Gravesham Borough Council's Post hearing Written Submissions - Issue Specific Hearing on Planning Policy and Environmental Matters (DEADLINE 3 – 30/04/2018)

**NOISE MONITORING LOCATION PLAN**

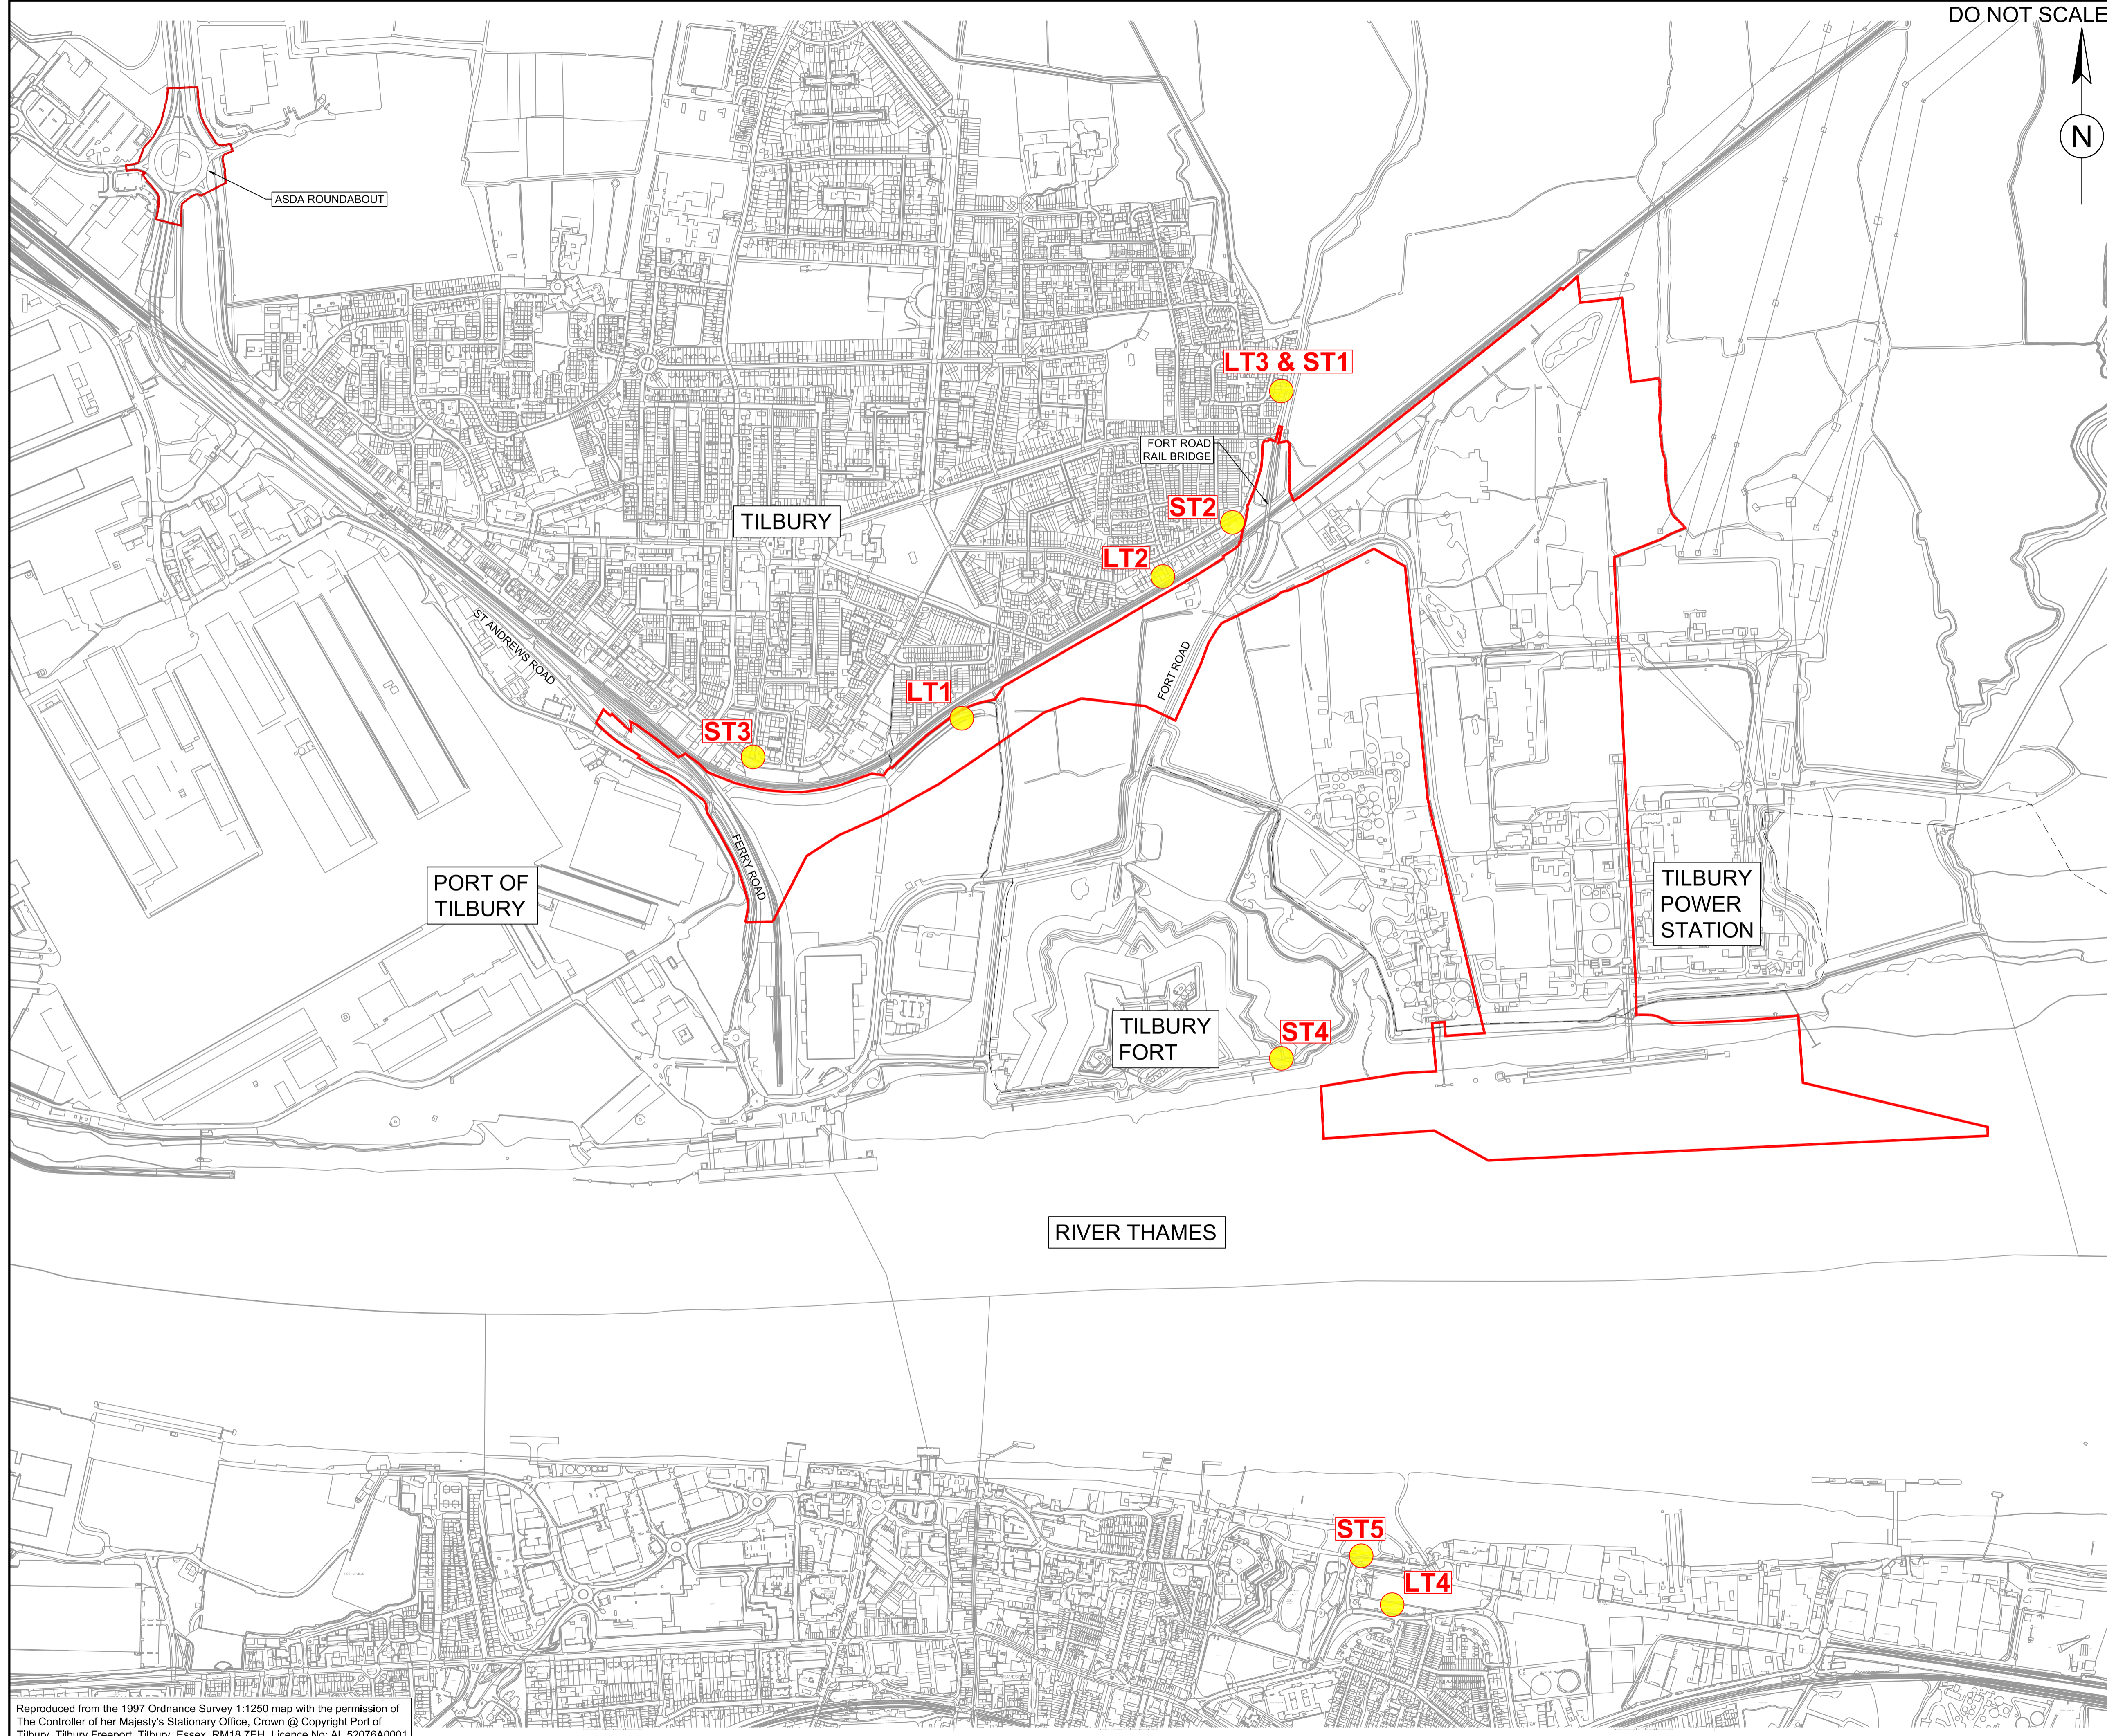
It is accepted by GBC that the predicted noise levels at Heritage Quay, and Chantry Court will be similar to those identified at NSR 7 (Clarendon road, Gravesend) and NSR 8 (Committed Development, Gravesend) but it is GBC's view that the residences at Mark Lane need further work so it can be understood whether the noise climate at that location is sufficiently different from other Gravesham receptors, particularly at night, to justify it being a separate monitoring location.
